[Planning Number: SSD-6693-Mod-2](#)

### Rye Park Wind Farm Mod 2

The Department of Planning and Environment – Crown Lands have reviewed the proposal.

Figure 4: Detailed overview of proposed modification (Inset 1)

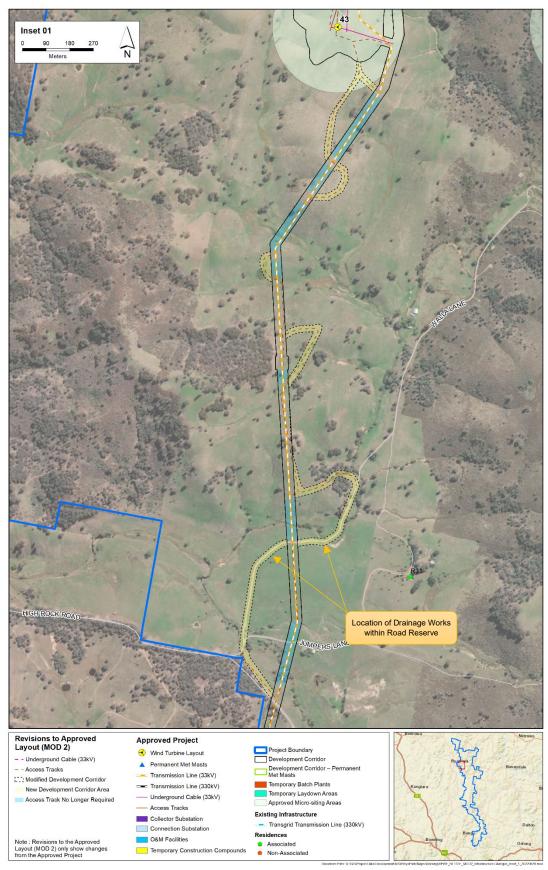
However, it is noted that the location of the proposed drainage works within the road reserve are occurring within a public road reserve under the control of Hilltops Council.

The intended use of a portion of the existing formation of Walla lane, identified as a Crown Public Road, is authorised under Crown licence 622918 the purpose of access.

Should any works be required on this portion of Crown Public road then approval via a road works application under s71 of the Roads Act will be required, in addition the relevant section of road may need to be transferred to Council. More information regarding Crown roads can be found at the following link: <https://www.industry.nsw.gov.au/lands/access/roads>
